## **Re: Submission to SSD-62855708 - Botany Waste Management Facility - 2-4 Hale Street, Botany NSW 2019**

We write to object to the proposed SSD. Our key concerns relate to the potential adverse traffic and parking impacts associated with the proposed waste management facility.

Swept Path Analysis

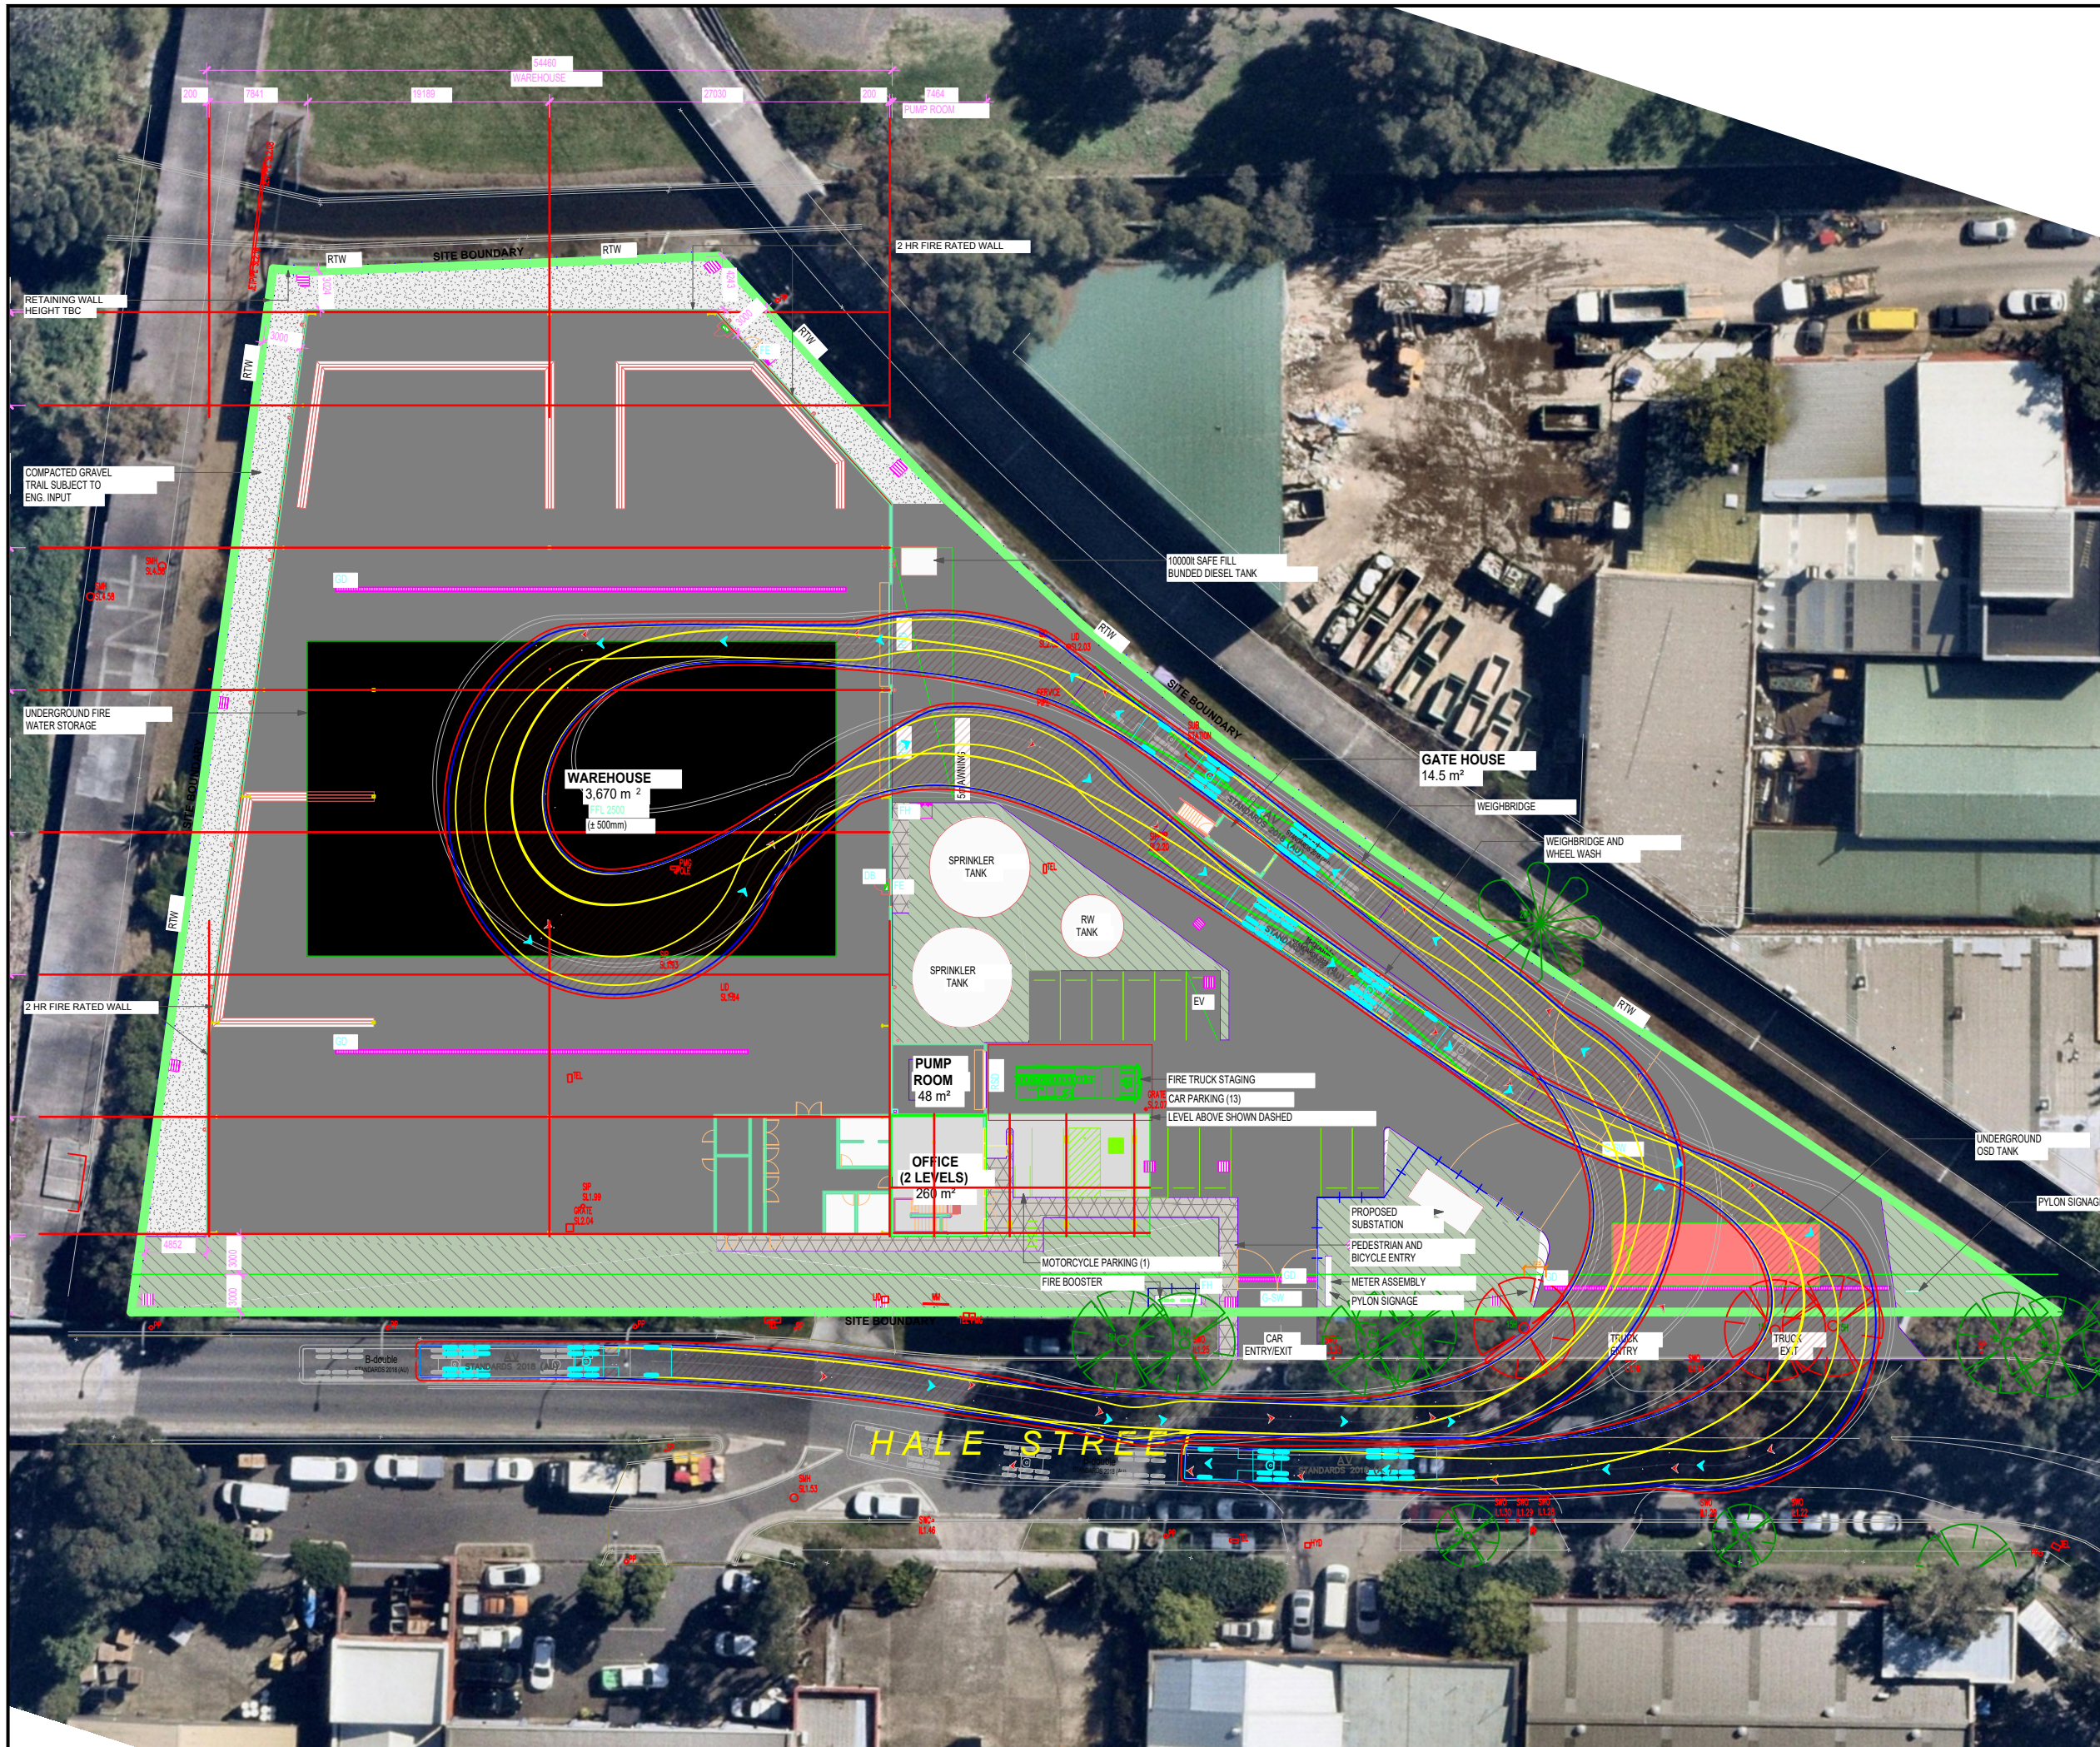
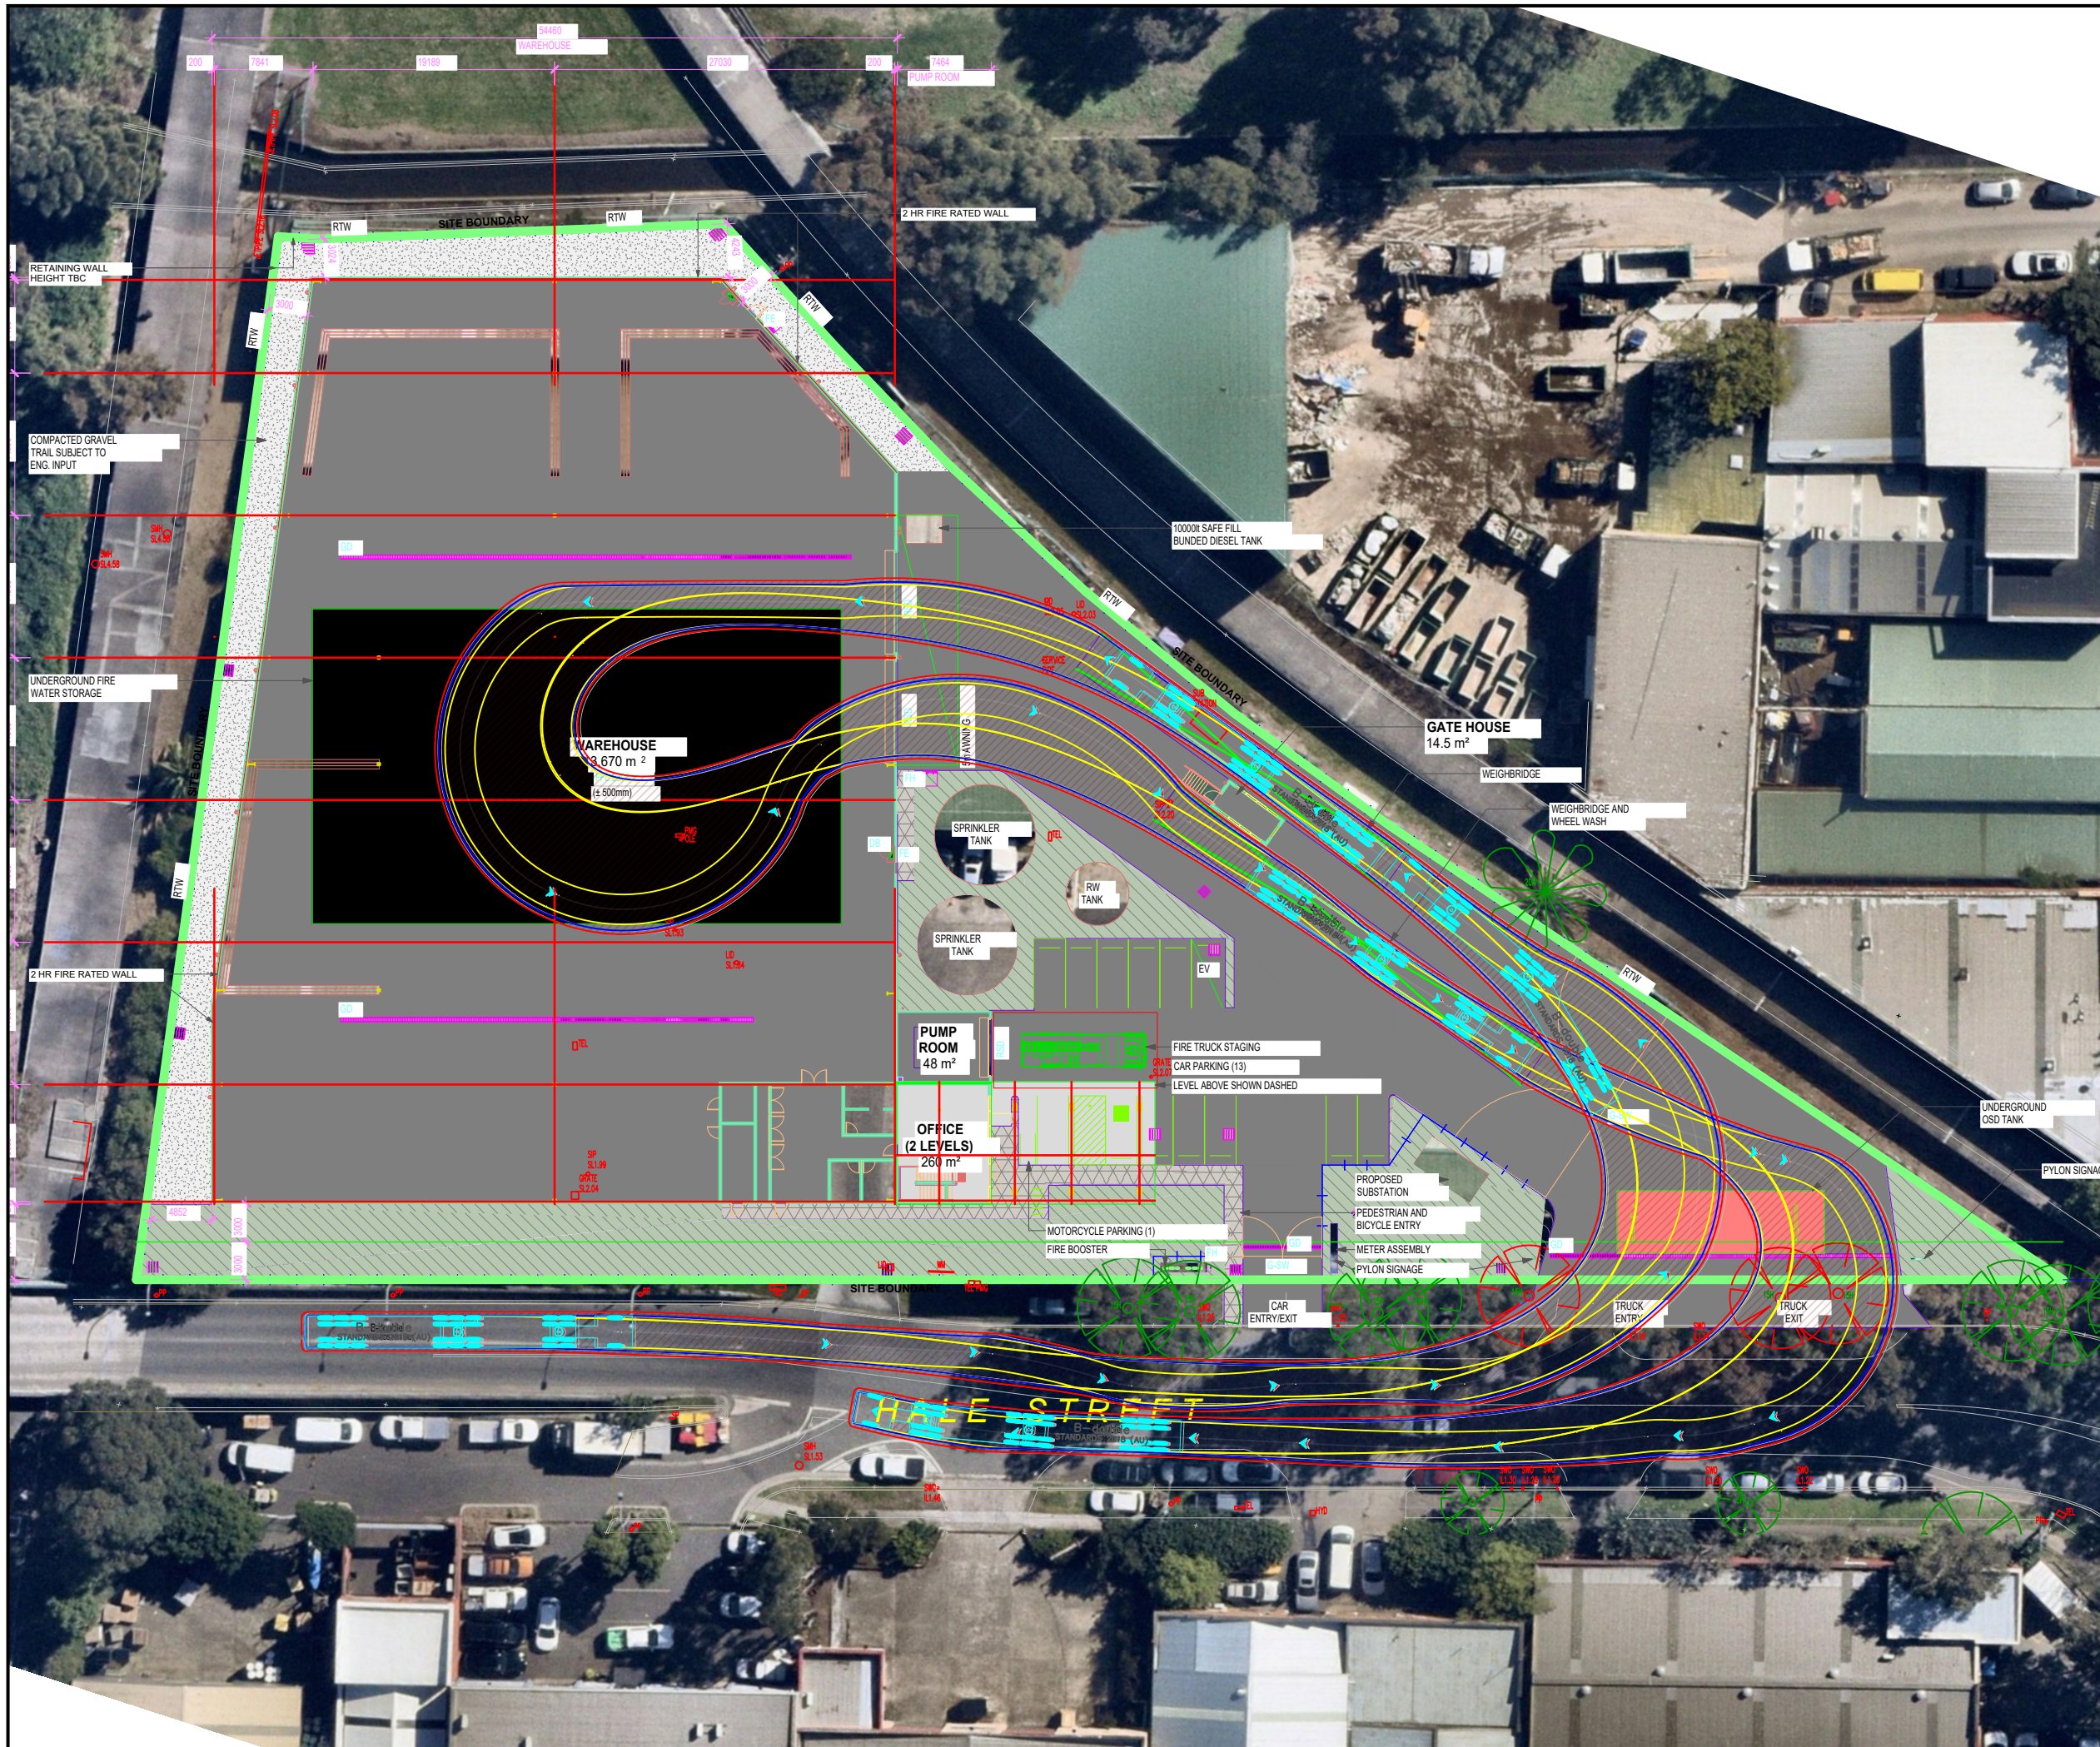
- The swept path analysis appears to indicate truck movements over the on-street parking spaces on the southern side of Hale Street, opposite the subject site.

In addition there appears to be the circumstance that additional on-street car parking spaces will be affected by the heavy vehicle truck swept paths entering and departing the site and this should be clarified.
